# **Gatwick Northern Runway Development Consent Order Application TR020005**

**Reigate & Banstead Borough Council 20044474**

**Principle Areas of Disagreement Summary Statement (PADSS)  
Version 4 Final Deadline 9 Submission Clean Version**

**21 August 2024**

Figure 1. Reptile Trapping Area A and Receptor Site

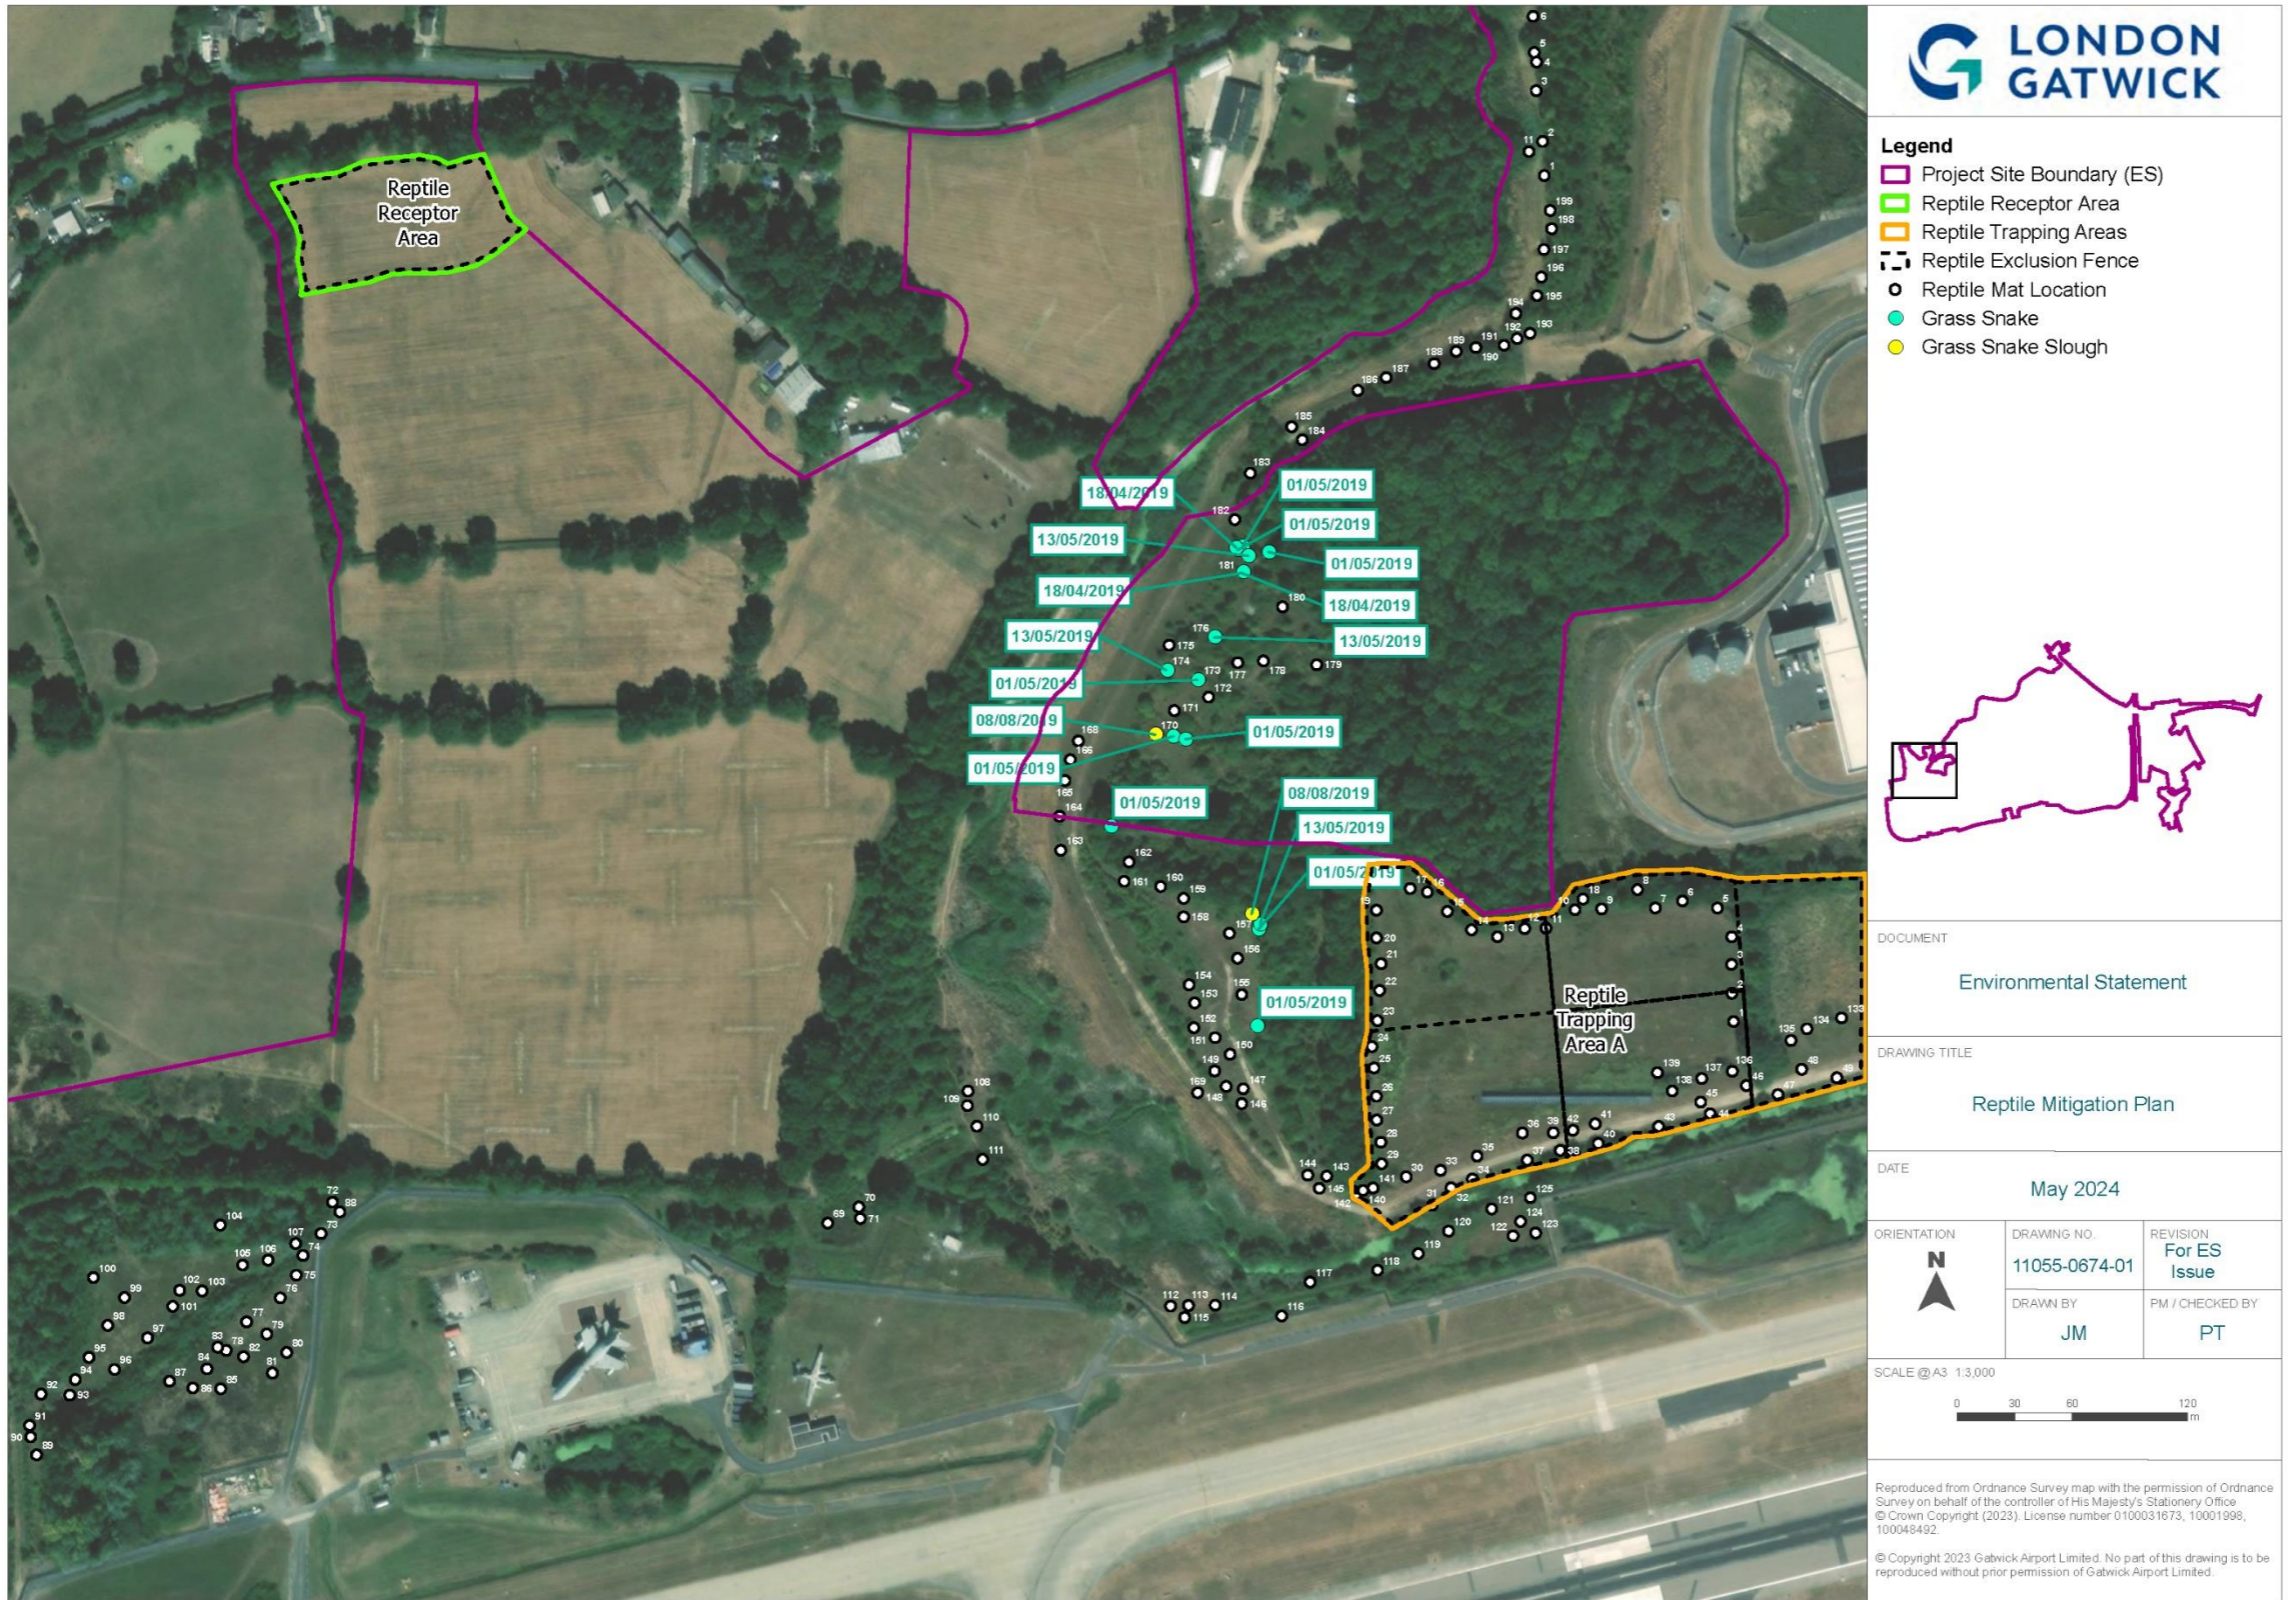
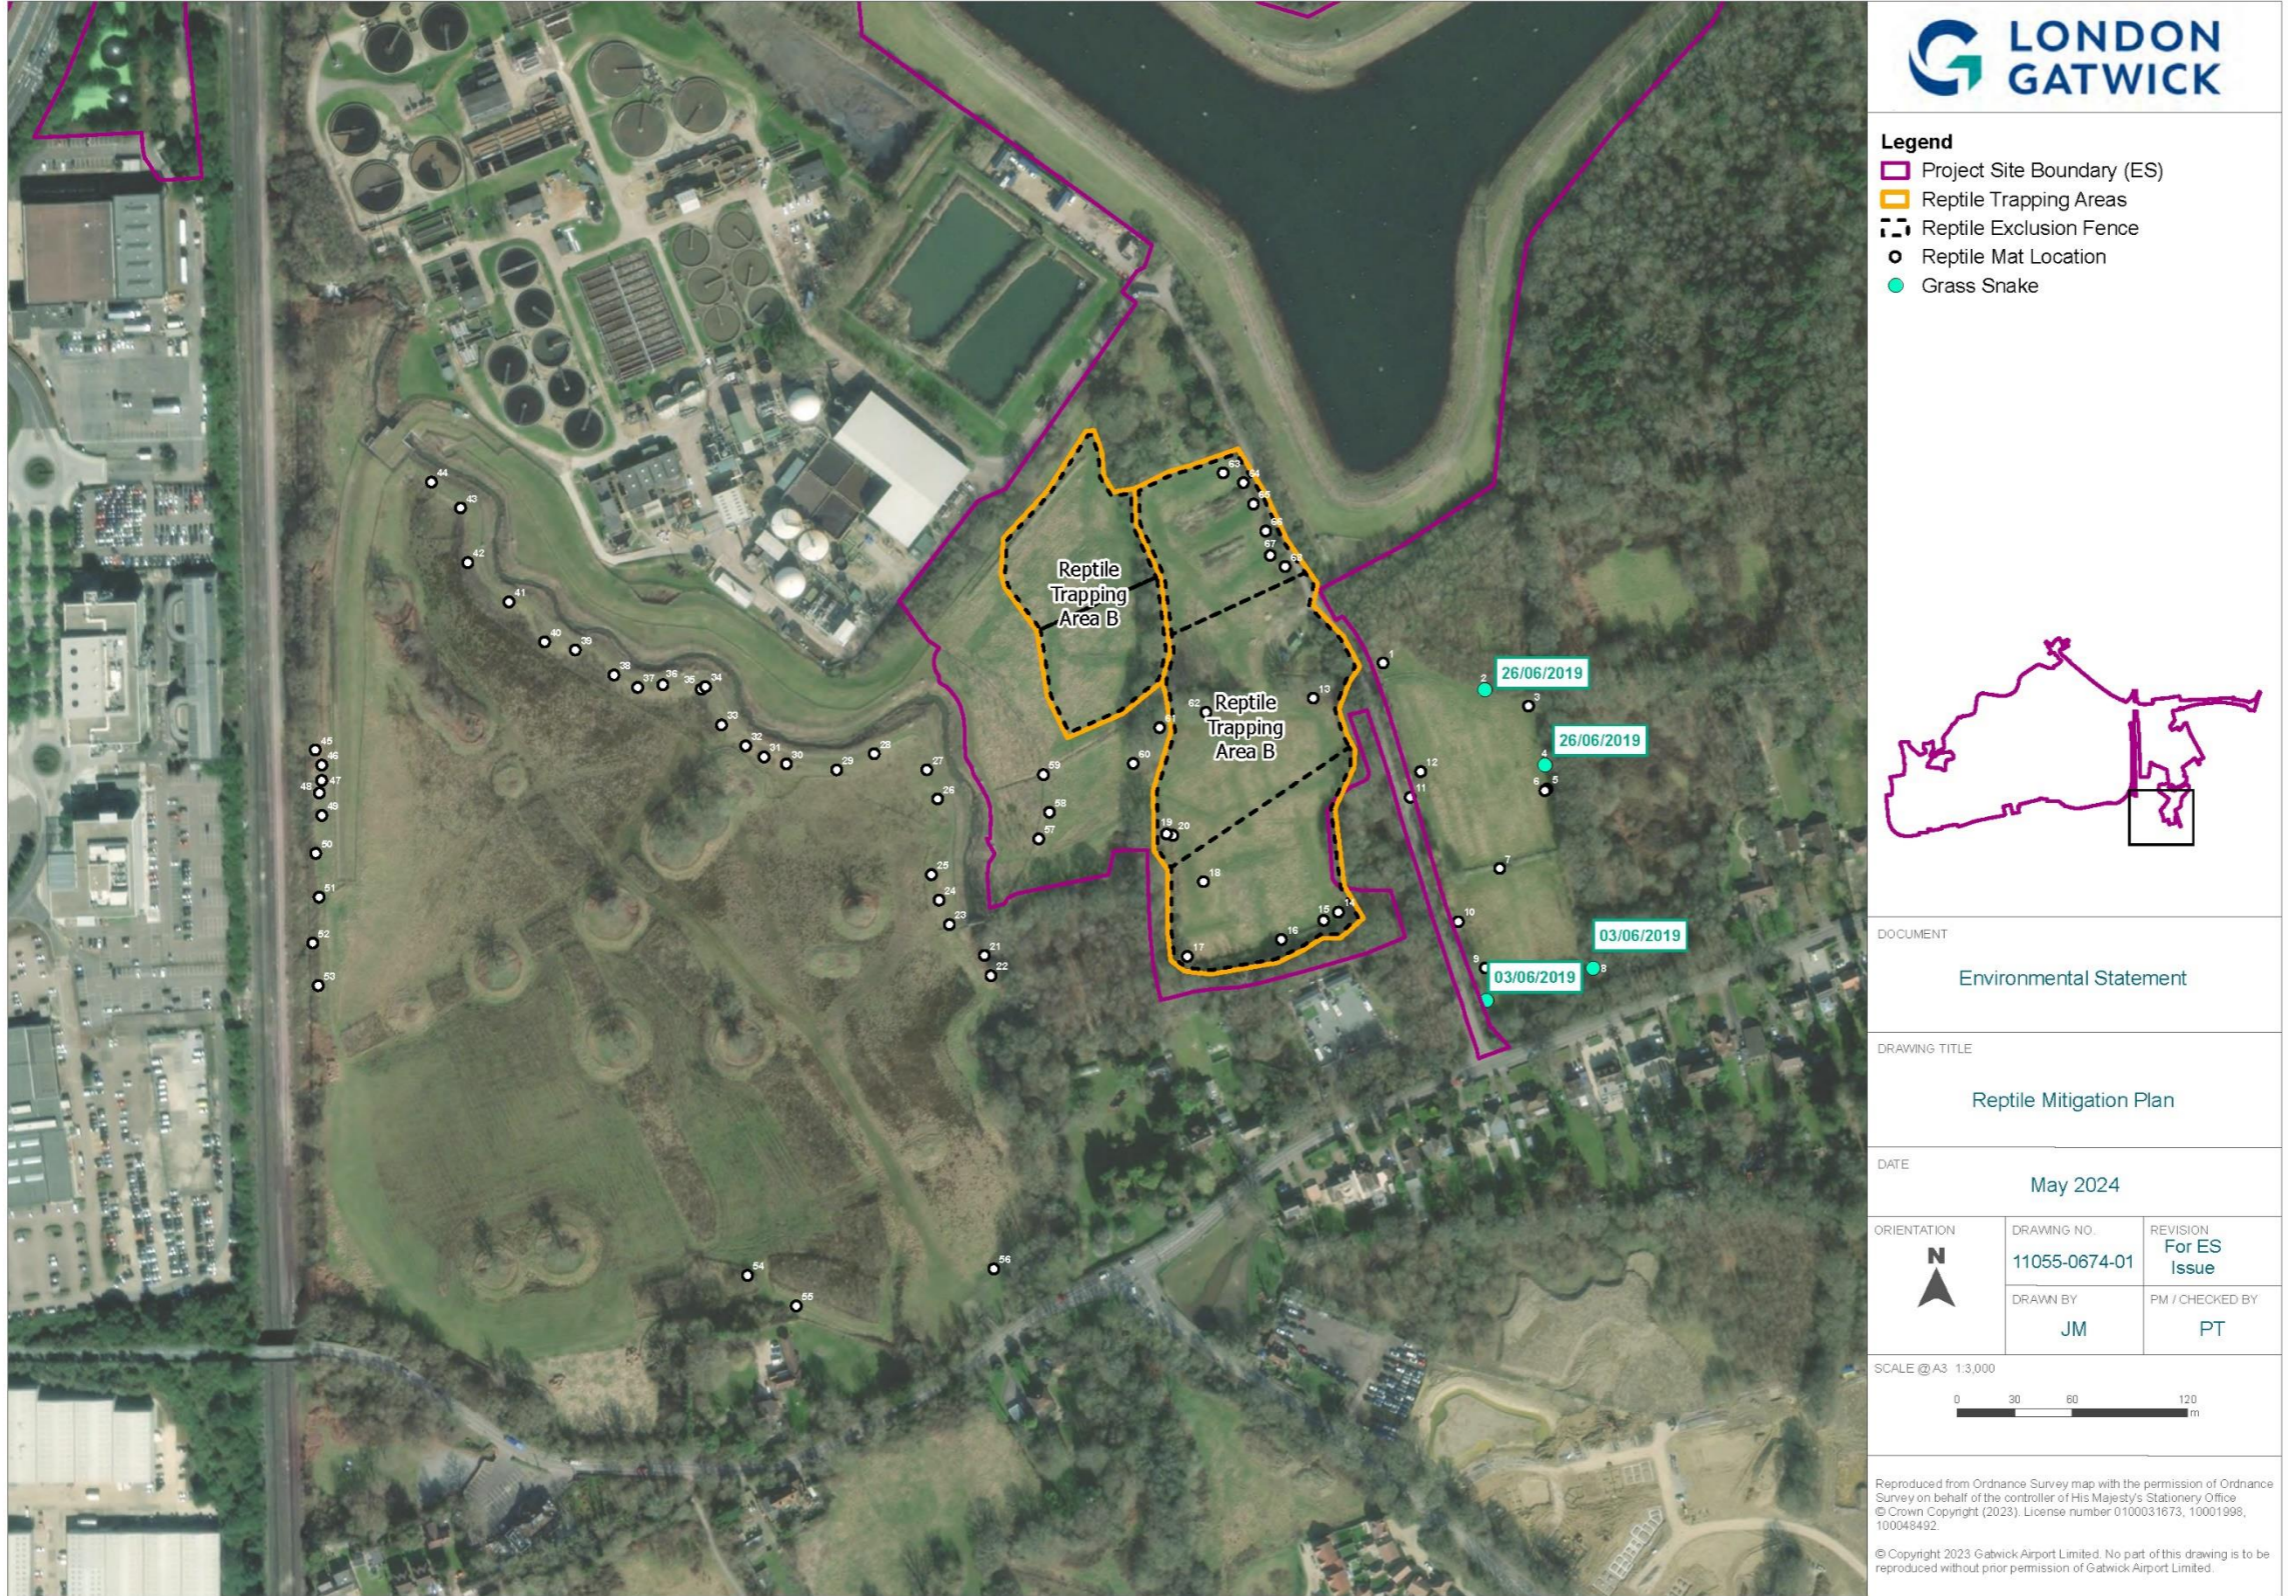
11.	Lack of information on reptile and great crested newt (GCN) mitigation	<p>The ecology chapter for the ES states that reptile and GCN mitigation will involve translocation to receptor sites and where relevant, European Protected Species Licences would be applied for post DCO consent. However, no detailed information is provided for the reptile and GCN mitigation strategy, for example:</p> <ul style="list-style-type: none"> <li>• Where are the receptor sites? Reference is made to Longbridge Roundabout, Museum fields and other mitigation areas but there is no detail as to which one of</li> </ul>	<p>Additional information has been provided in the Applicant’s SoCG response. This should be included within the submission documentation. It remains unclear whether residual impacts have been assessed appropriately without having an outline mitigation strategy in place.</p> <p><b>Updated position (Deadline 5):</b> It is standard practice for an outline mitigation strategy to be submitted</p>

<p>these has been chosen to be the receptor locations for reptiles and GCN.</p> <ul style="list-style-type: none"> <li>No methodology or timings information for the mitigation strategies.</li> </ul> <p>Whilst it is appreciated that this is outline consent, an outline mitigation strategy is still required for reptiles and GCN.</p>	<p>prior to planning approval. Whilst we appreciate the finer detail will come later, a high level overview is required so as to be satisfied that the 'favourable conservation status' of the population will be maintained. We will review the Deadline 5 submission.</p> <p><b>Updated position Deadline 9:</b> RBBC note that SCC ecologists welcome the reptile mitigation strategy and that there remain a number of outstanding comments/updates required. However, RBBC is no longer pursuing as we see this as a matter between SCC and the Applicant.</p>
